DRB CASE ACTION LOG

DRB Application No.: 03-00467 (SBP)
Project Name: UNM PARCELS
Agent: Lee Gamelsky Architects PC

Project # 1002402
EPC Application No.: Z-68-90, 02-01942, Z-83-33
Phone No.: 572-8865

**SITE PLAN**  
 By: \_\_\_\_\_ m  
 File: \_\_\_\_\_ \*DWG  
 Sheet  
**AS-1.0**

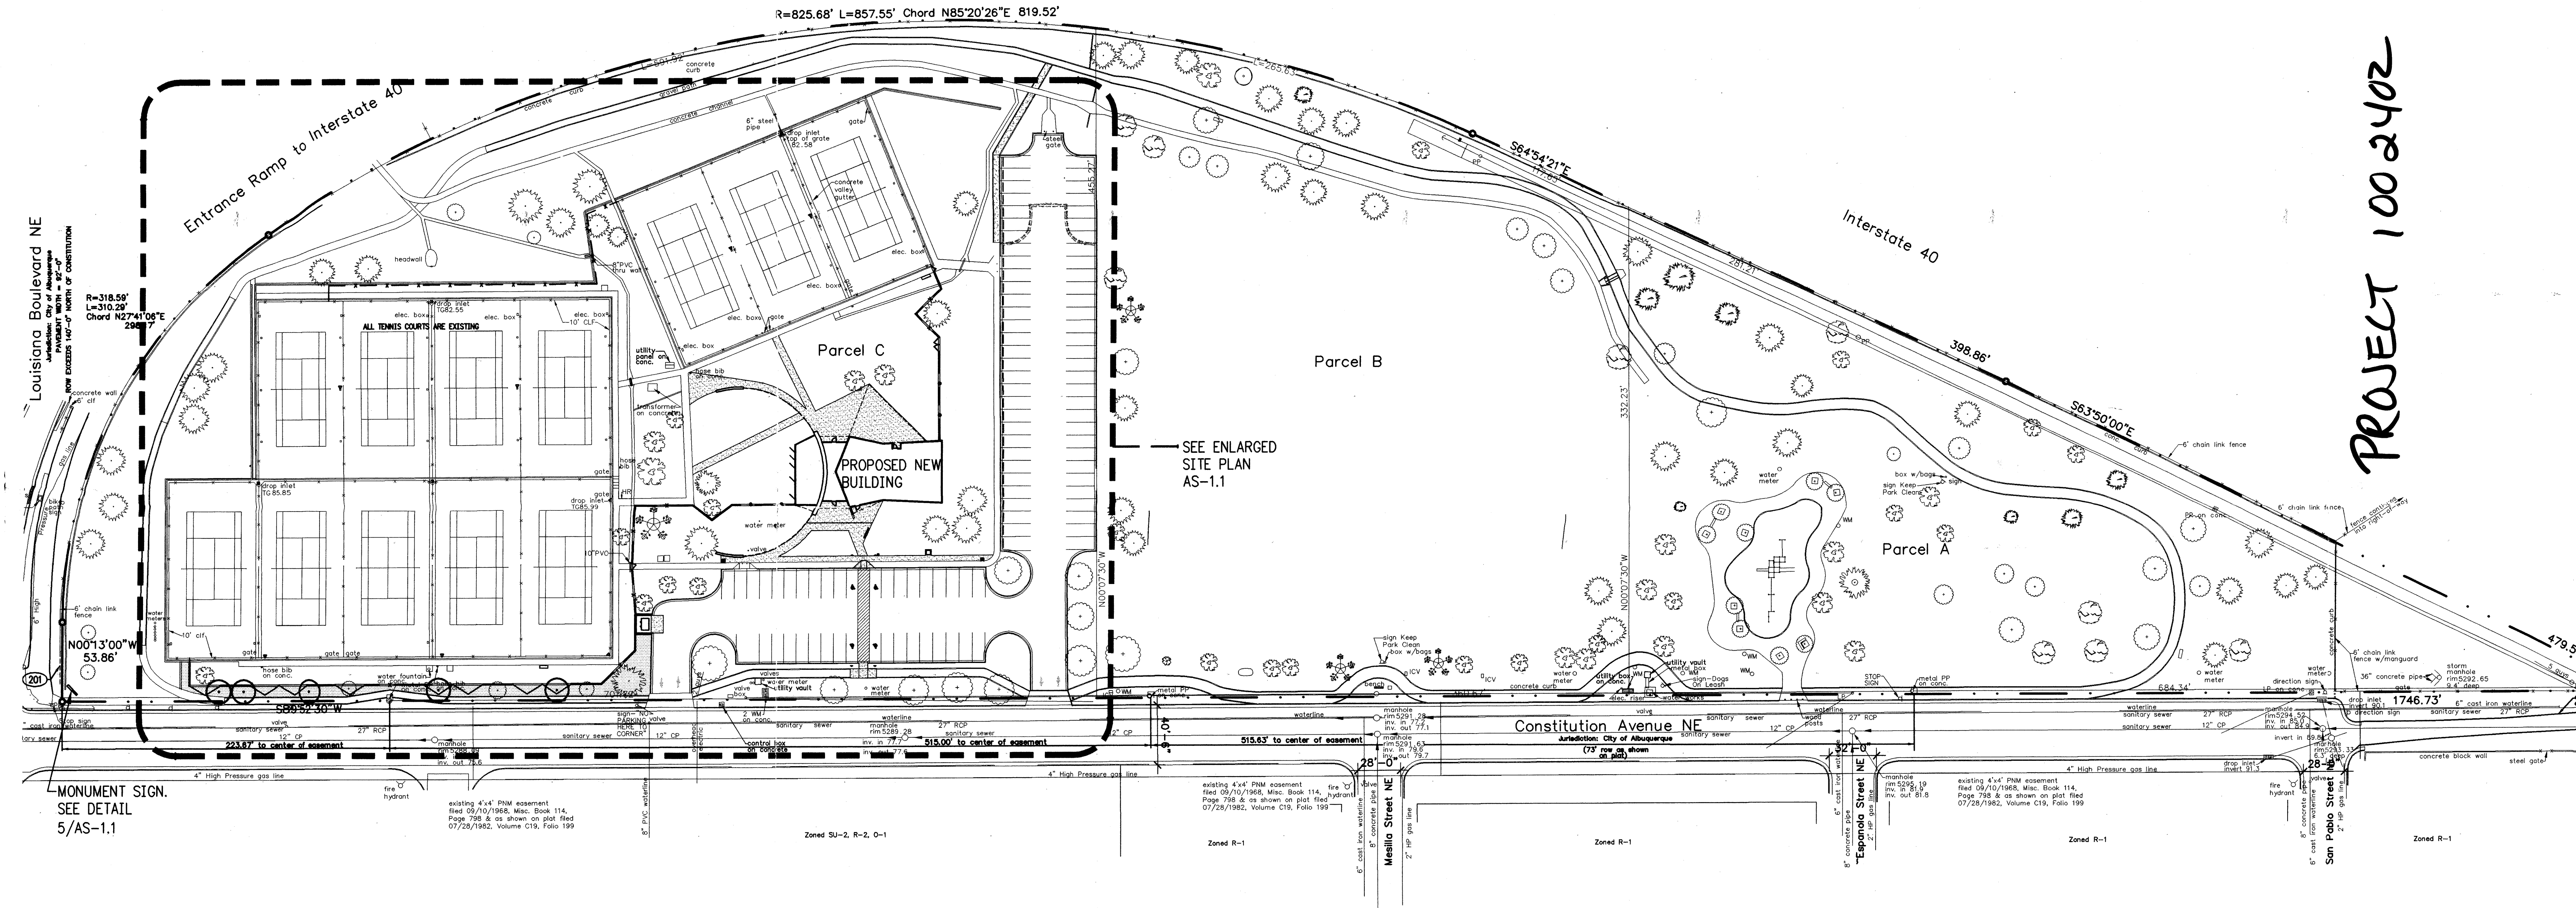
TRANSPORTATION:
 Public works need to be contained within
 Public Easements or Right-of-way.

UTILITIES: Verify Sewer Account (done, completed)
 Revise Drawing to show existing Sewer Service.
